From: Zac Denton [REDACTED]
Sent: 21 June 2021 09:14
To: Kathryn Welch
Subject: RE: AB/55/21/L & AB/59/21/A

I've had a chance to take a look at this application now and discuss with Dan and I have some comments relating to the conservation's officers representations.

DRAWING TITLE  
PROPOSED BASEMENT PLAN, FIRST  
FLOOR PLAN AND FRONT ELEVATION

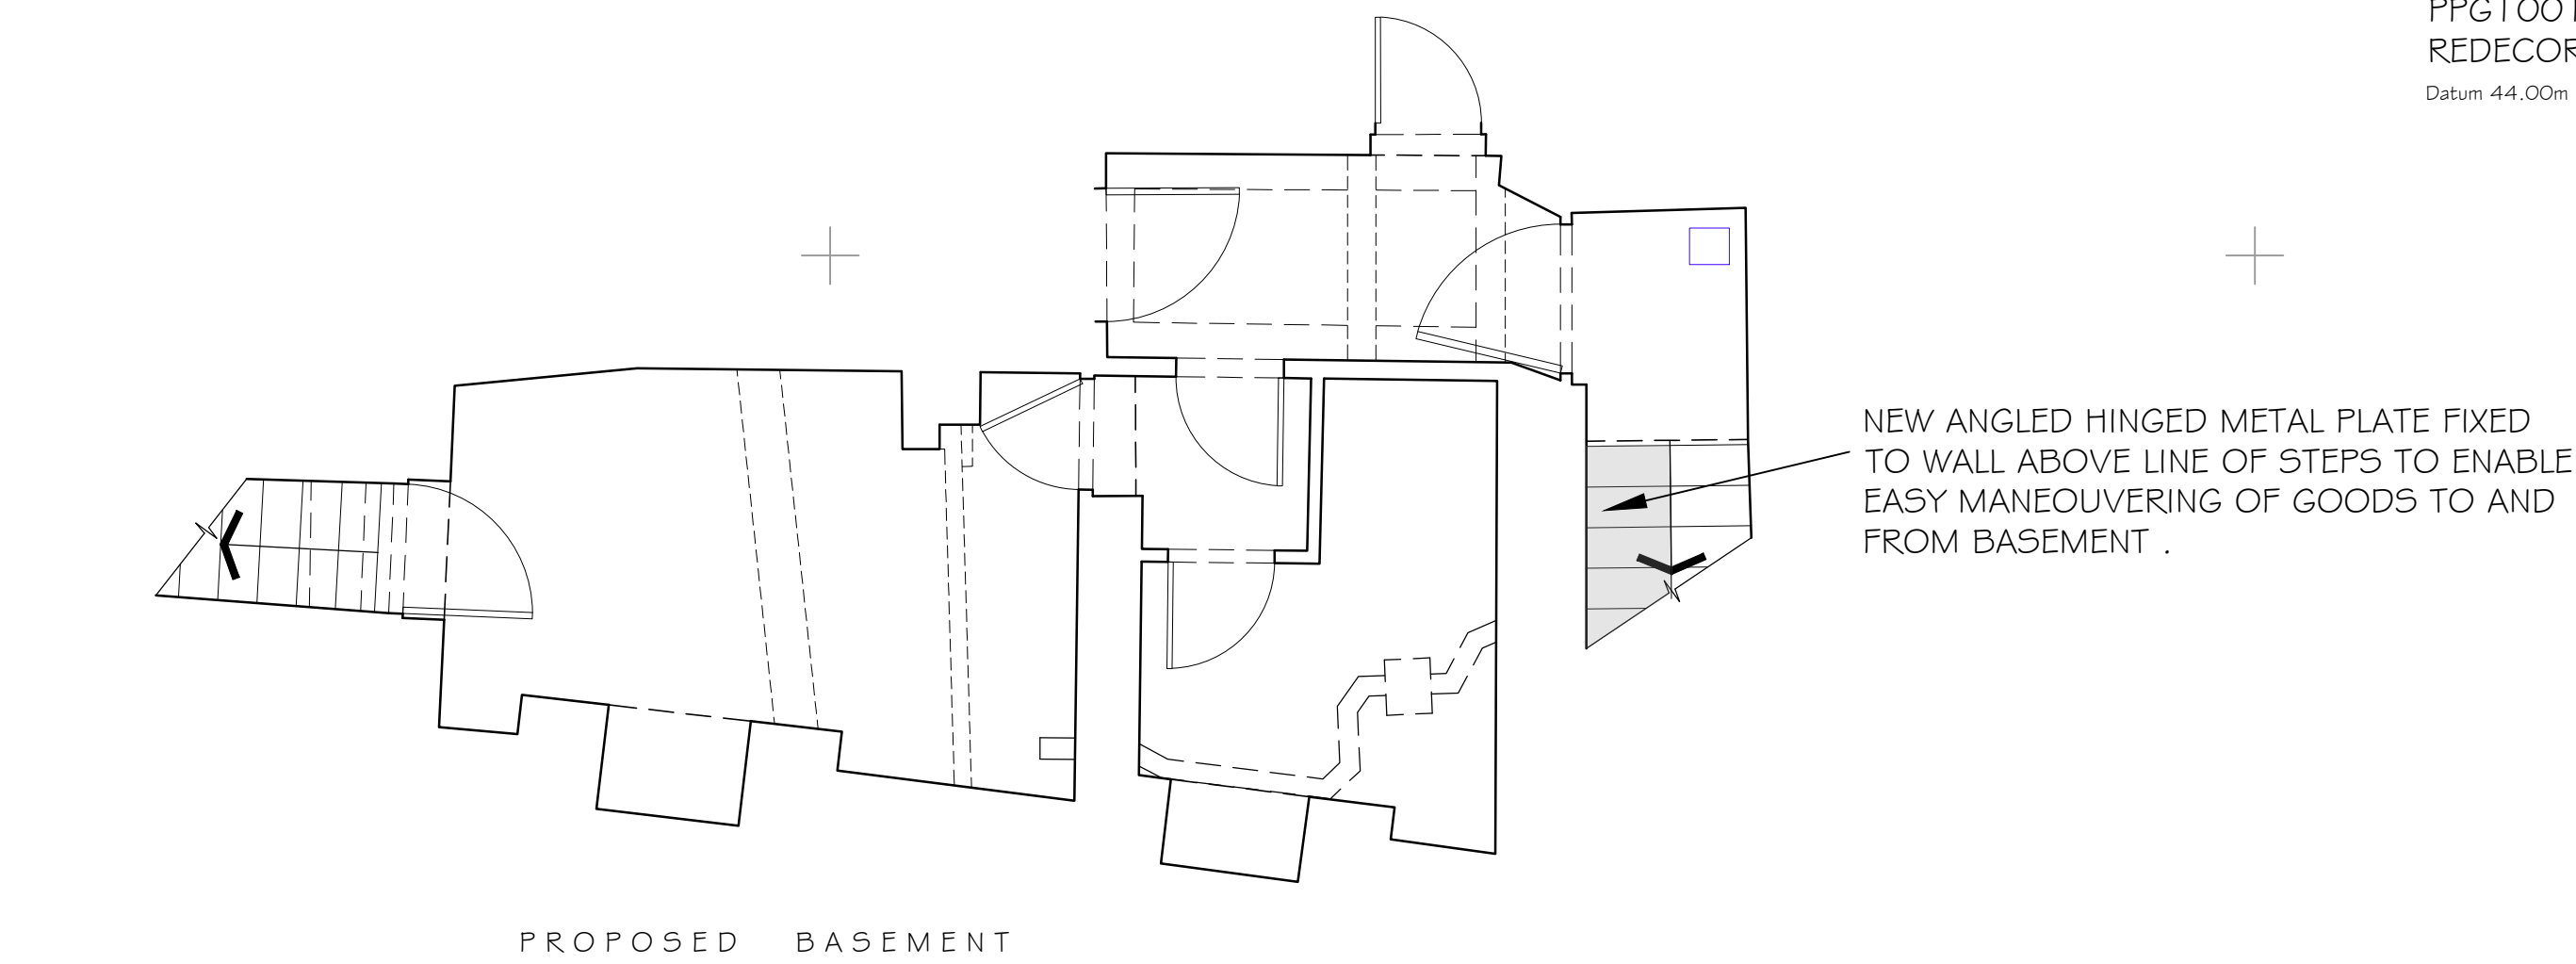
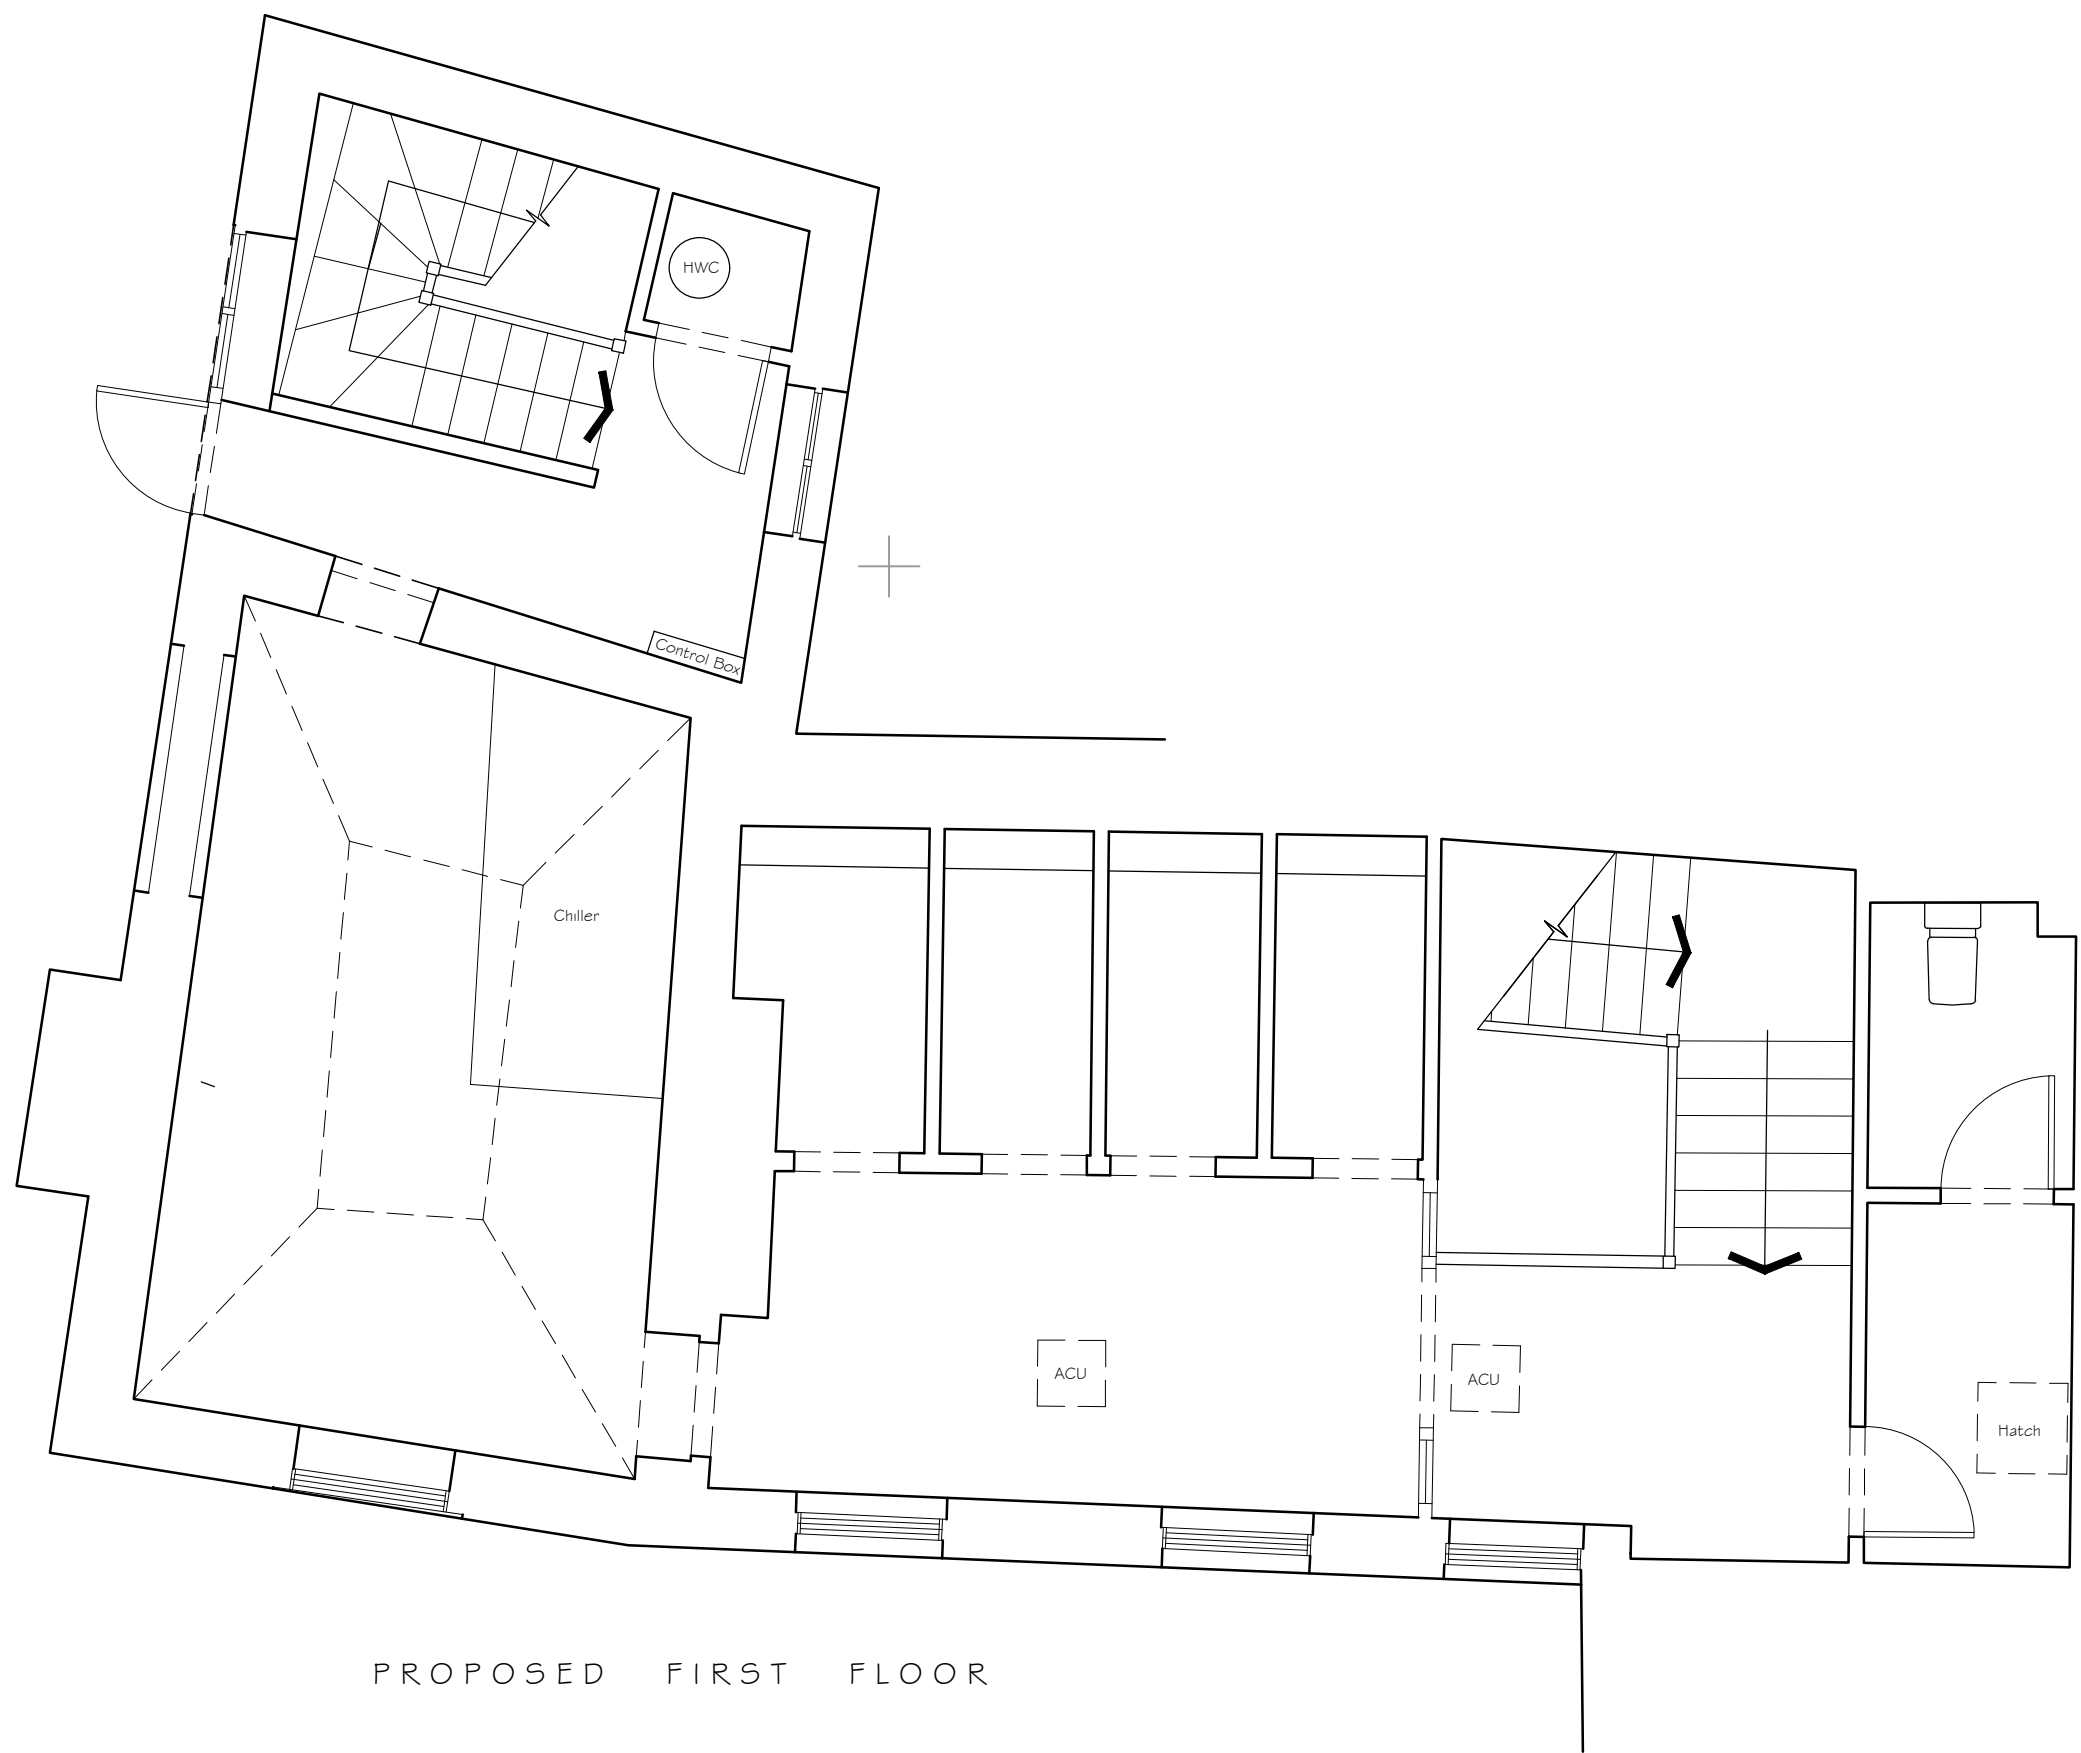
It is felt that the addition of the 4 external downlights over the halo signage, is out of character for the area and would leave the frontage overly lit when compared with other buildings in the area. It is noted that there are a few examples of lantern style lights to the frontages of some of the buildings however these properties do not benefit from any other lighting. Together, the halo lighting and downlighters would be incongruent in the street scene and we would be grateful for their removal.

Secondly, I'm in agreement with the conservation officer when he states the painting of the sills in dark grey and colour change of the windows would be 'awkward' to the building's frontage. A colour to match the sills at first and second floor level would be much more appropriate. This would ensure the retention of a unified frontage in line with the comments. In turn it is considered the colour of railings and the ramp would be jarring if changed to grey, and they would benefit in being black.

I have discussed the proposed changes with the client, and can confirm he is happy to remove the external downlighters from the front elevation of the building.

Following our discussions over the phone, I can confirm the proposed colour to be 1001-6 Knight's Armour. Please see the link here: <https://www.brewers.co.uk/product/AF033515N/PPG1001-6+Knight's%20Armor>

As can be seen, the proposed colour change is unlikely to appear out of character with the street scene, due to the fact that it is so similar to the existing colour.
